Re: **5th Street**
1715 5th St NW
Traffic Circulation Layout
Architect's Stamp 06-17-2021 (H14-D100A)

Based upon the information provided in your submittal received 06-22-2021, the above referenced plan cannot be approved for Building Permit until the following comments are addressed:

Sheet: Traffic Control Layout

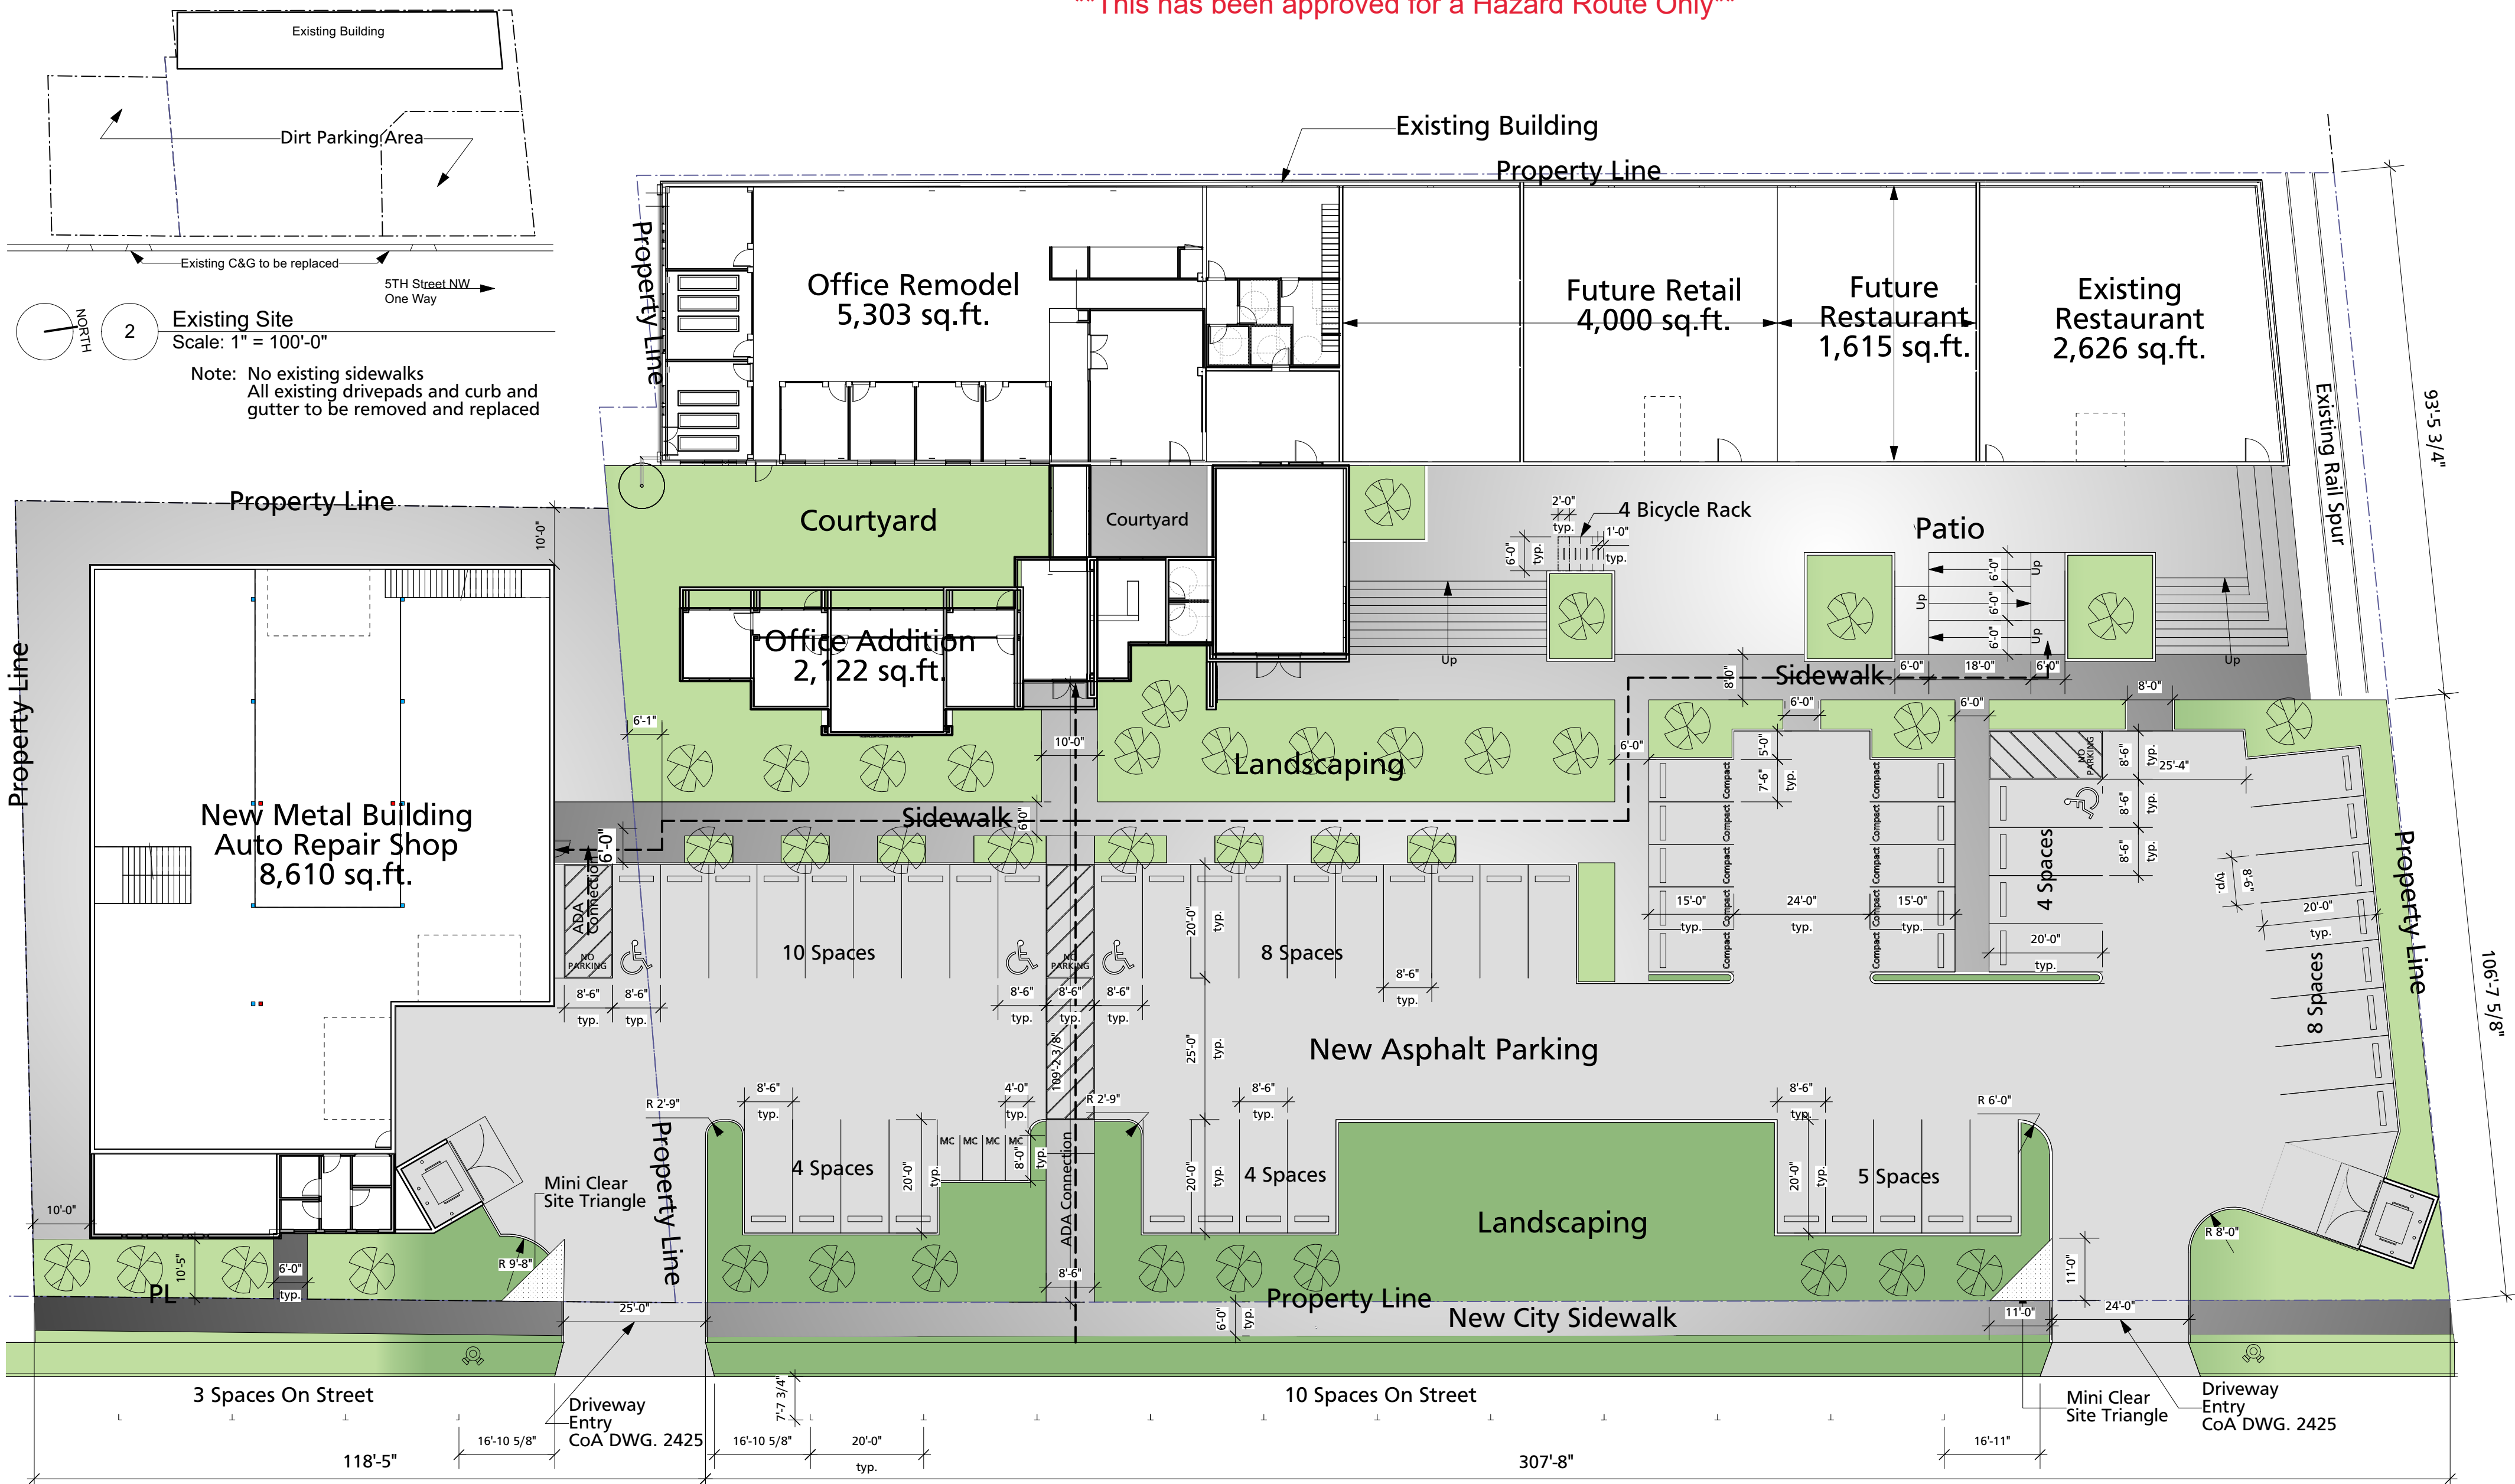
2. Clarify existing property lines and proposed property lines: **Clarify the extents of the current phase. Provide a phasing plan. Property lines are don't match AGIS please clarify. Show adjacent properties to establish the overall site to determine whether a share access easement is needed.** There are no legend to define line types.

5. Please identify all existing buildings, doors, structures, sidewalks, curbs, drive pads, wall and anything that influences the parking and circulation on the site.

8. Clarify existing property lines and proposed property lines. Shown on on public street (5th St NW) are parallel parking spaces, provide stalls dimensions and setback measurements from each driveway. You show a lot of line types aren't define.

9. Public sidewalk: Status? Existing or proposed? Width need to be provided.
10. Drivepad status? Existing or proposed? The driveway appear to be non ADA access. Provide drivepad design that is ADA accessible (reflect COA std dwg).

11. Please list the width and length for all existing and proposed parking spaces. **Some dimensions are not shown.**
12. The minimum parking stall dimensions are:

20. List radii for all curves shown; for passenger vehicles. Radius for delivery trucks, **fire trucks, etc. is 25 ft. or larger.**
21. Per the IDO, a 6 ft. wide ADA accessible pedestrian pathway is required from the public sidewalk to the building entrances. **Please clearly show this pathway and provide details. Dimension the proposed pathway and provide ADA ramp design for the pathway.**

22. Per DPM, a 6 ft. wide ADA accessible pedestrian pathway is required from the ADA parking stall access aisles to the building entrances. **Please clearly show this pathway and provide details.**

25. **Please provide a sight distance exhibit. You show a clear sight line but it is obstructed by on street parking. Please provide the drivepad clear sight triangle on each.**

26. **Show the clear sight triangle and add the following note to the plan: "Landscaping and signage will not interfere with clear sight requirements. Therefore, signs, walls, trees, and shrubbery between 3 and 8 feet tall (as measured from the gutter pan) will not be acceptable in the clear sight triangle.**

5 HC / Motorcycle Sign Detail Scale: 3/8" = 1'-0"

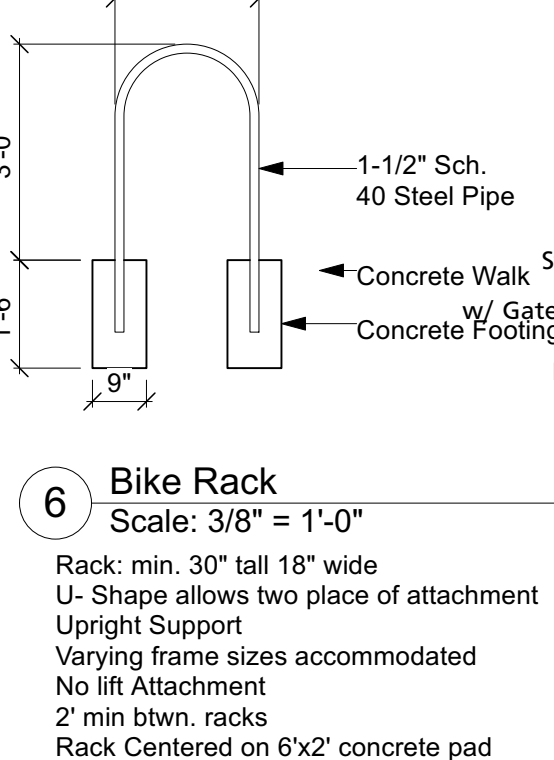
15. Motorcycle parking spaces shall be designated by its own conspicuously posted upright sign, either free-standing or wall mounted per the zoning code. **Label pavement MC for each space/stall.**

6 Bike Rack Scale: 3/8" = 1'-0"

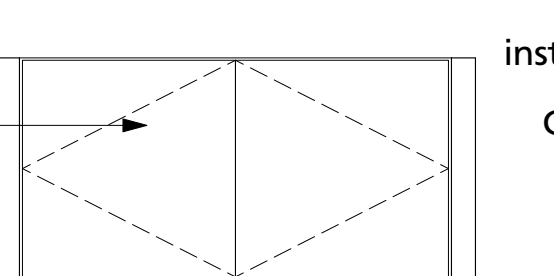
16. All bicycle racks shall be designed according to the following guidelines:
 - a. The rack shall be a minimum 30 inches tall and 18 inches wide.
 - b. The bicycle frame shall be supported horizontally at two or more places. Comb/toaster racks are not allowed.

- c. The rack shall be designed to support the bicycle in an upright position. See the IDO for additional information.
 - d. The rack allows varying bicycle frame sizes and styles to be attached.

- e. The user is not required to lift the bicycle onto the bicycle rack.
 - f. Each bicycle parking space is accessible without moving another bicycle.

17. Bicycle racks shall be sturdy and anchored to a concrete pad.
18. A 1-foot clear zone around the bicycle parking stall shall be provided.
19. Bicycle parking spaces shall be at least 6 feet long and 2 feet wide.
